Hydrograph by Return Period

Project Name: Native Sun Construction, Proposed Drainage Plan, CD Civil Design LLC

PROPOSED
DRAINAGE
PLAN

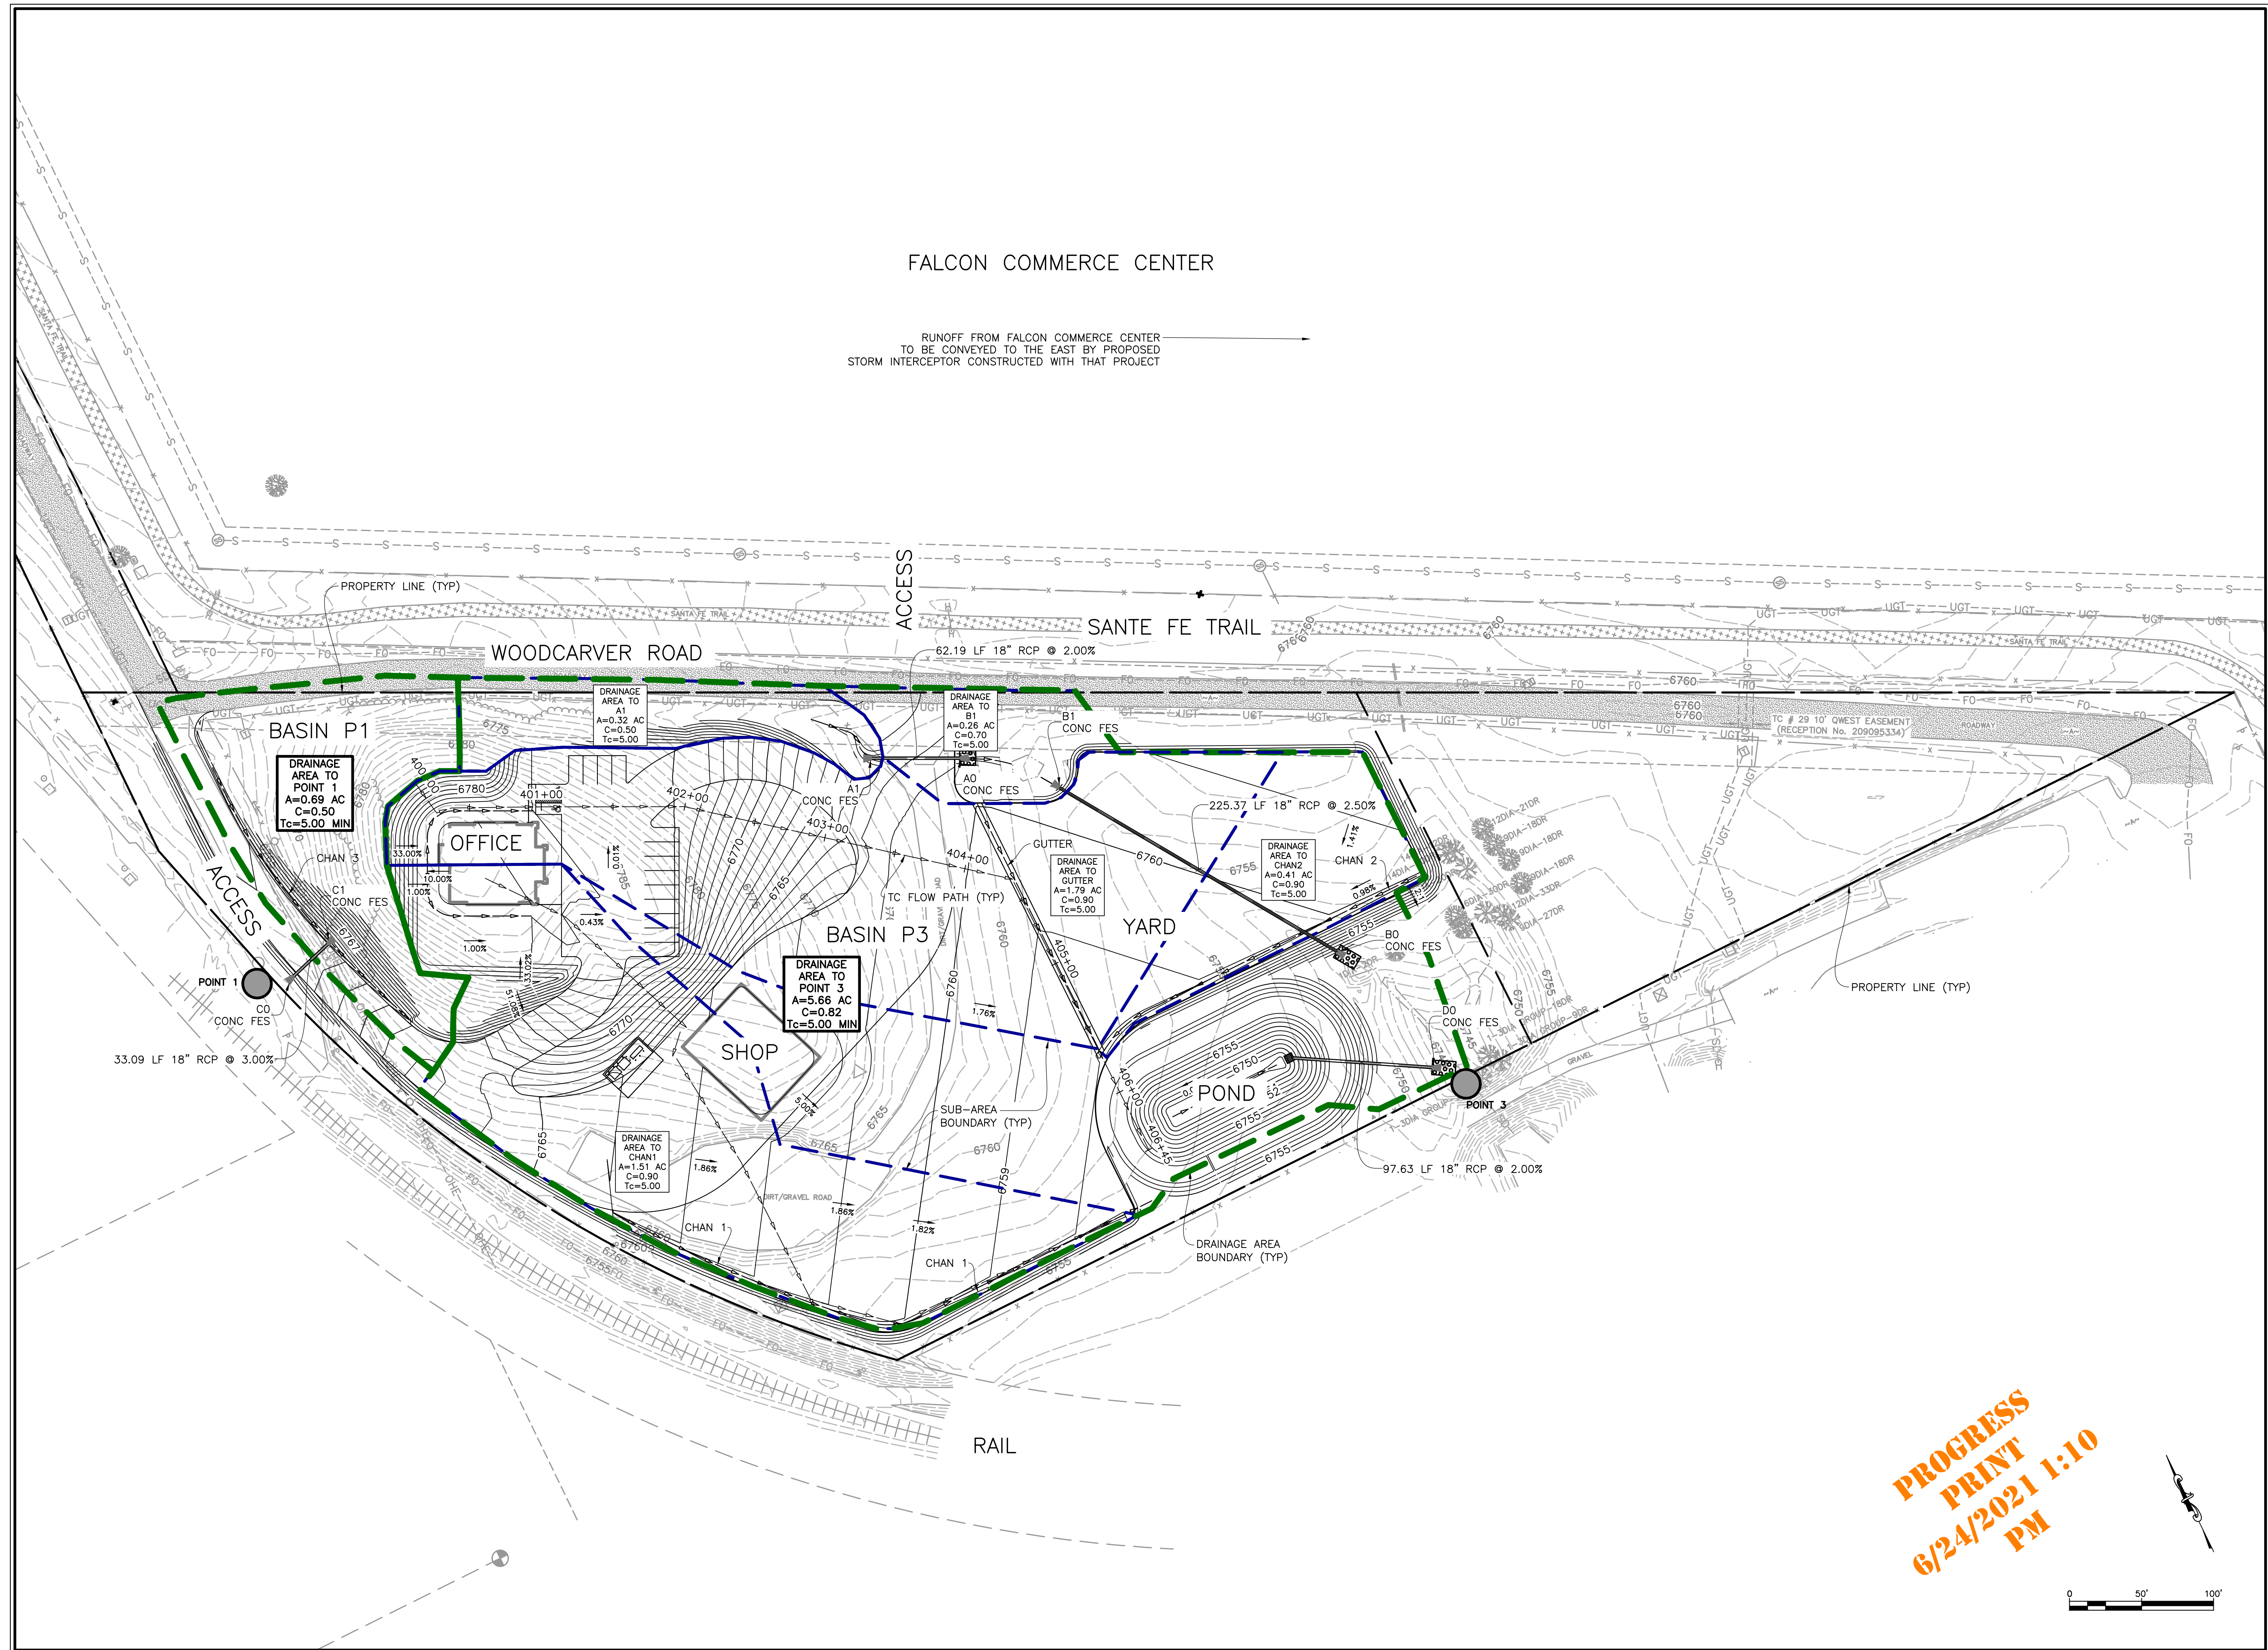
Check Calculations for Basin P1 and Basin E1. This design point discharges into Unincorporated El Paso County and the proposed condition peak flow rate is greater than existing. Per County criteria the flow exiting the property must be equal to or less than historic.

Additionally, provide analysis from the pipe to the suitable outfall. The proposed condition has change the characteristics of the runoff from sheet flow to concentrated flow. Additional offsite improvements may be required if the flow path between the pipe and what is considered the suitable outfall is shown to not be hydraulically adequate. See the County's Engineering Criteria Manual Chapter 3 Section 3.2.4 for the definition of suitable outfall.
